**RE: UNM Airport Lease Parcel, N15/D1c, Engineer's Stamp Dated 8/3/99, Received 8/4/99,
Drainage Concept Approval**

***RE: UNM AIRPORT LEASE PARCEL (N15-D10). CONCEPTUAL GRADING AND
DRAINAGE PLAN FOR DRAINAGE REQUIREMENTS. ENGINEER'S STAMP
DATED DECEMBER 10, 1998.***

**RE: Master Drainage Report and Conceptual Grading Plan for
U.N.M. Airport Lease Parcel
Unplatted Lands of U.N.M.
Stamped 12-10-98 by Jeffery Mortenson, P.E.**

CONCEPTUAL GRADING PLAN  
U.N.M. AIRPORT LEASE PARCEL MASTER PLAN

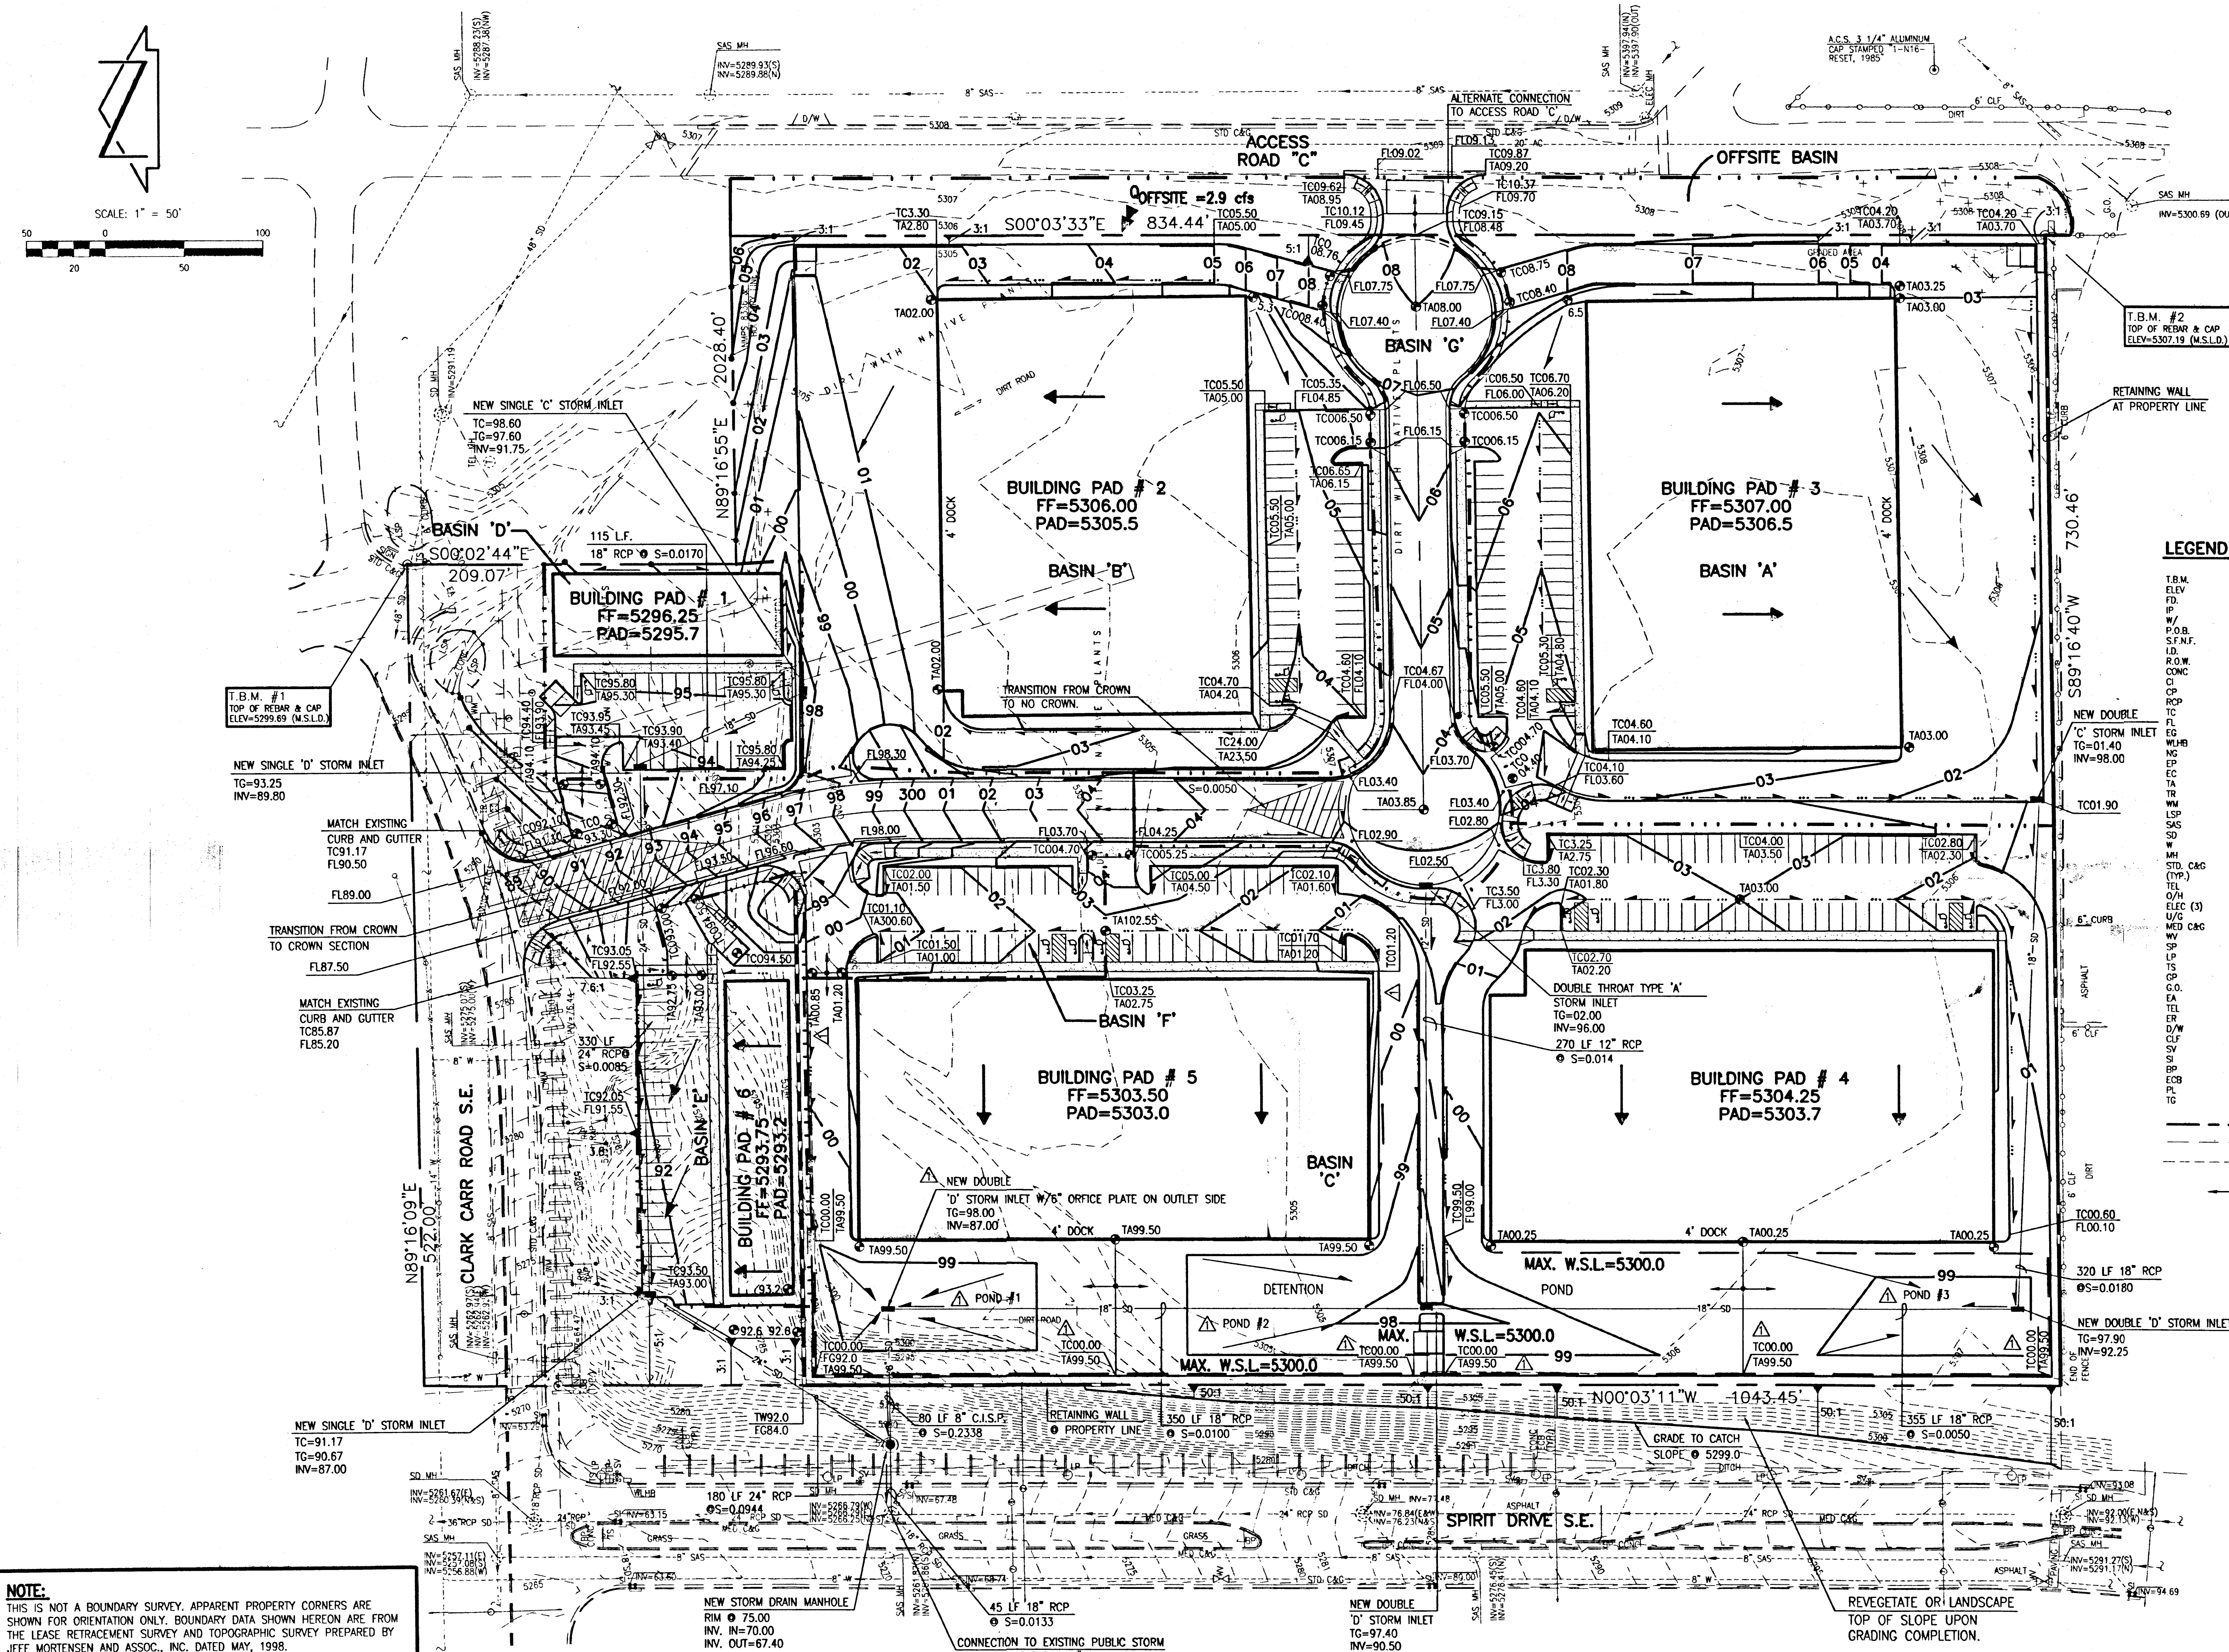
2. Sheet 3 of 5 - Need a note on the upstream end of the 8-inch storm drain at the type Double D inlet to install a 6-inch orifice plate on the 8-inch pipe.

3. Sheet 3 of 5 - Need a manhole at the intersection of the 12-inch and 18-inch storm drains.

4. Sheet 3 of 5 - Need to show the Double D storm inlet located in the middle of the detention pond (there is a note but is not shown).

5. Sheet 3 of 5 - There appear to be some "typos" regarding TC elevations along the detention pond (TC300.00)
6. Sheet 4 of 5 - Basin "A" calculations indicate a Double D inlet, Sheet 3 of 5 shows a Double C inlet (which is correct and are the hydraulic calculations correct?).
